**Consultation Response from KC,
Highways Development Management****2025/92206 42, Robin Royd Lane, Mirfield, WF14 0LG****Demolition of existing dwelling and erection of five dwellings with associated external works****Date Responded: 30/10/2025****Responding Officer: CNB****Responding Ref: K10-11SE/4**

PROPOSED GROUND FLOOR PLAN

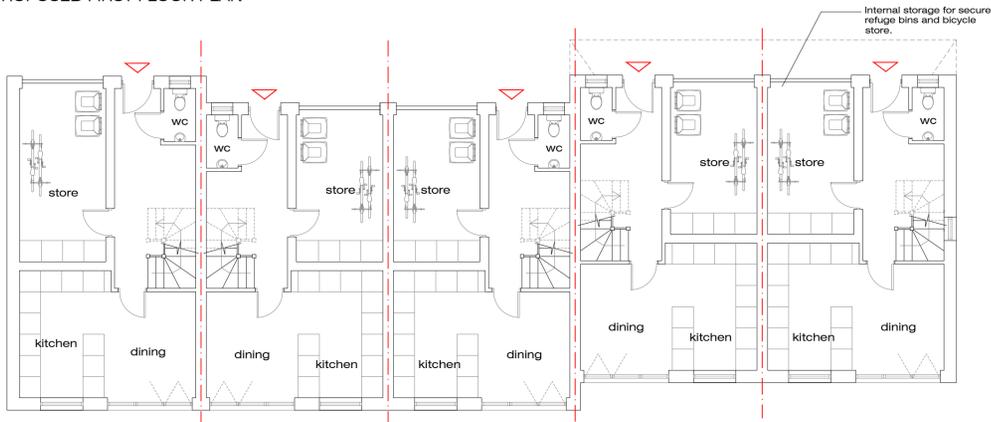
There appear to be integral garage like rooms included in the easternmost four dwellings, however these are below the required internal dimensions of 3m x 6m to be considered as garages and are subsequently marked as "storage".

There have been concerns that the storage room or study shown on drawing No 3115 004 Revision I could be turned into a bedroom, and this would increase the number of bedrooms to four per dwelling and as such each dwelling would then require 3 off-street parking spaces. As we do not feel that the additional car parking spaces can be provided within the site, we would wish to see some protection through the planning process to have these rooms preserved as they are and the dwellings to remain as 3-bedroom dwellings.

Drawing No 3115 004 Revision I shows that each dwelling has storage space for a bicycle and this is acceptable, and these cycle storage spaces should be preserved for the full lifetime of the development.
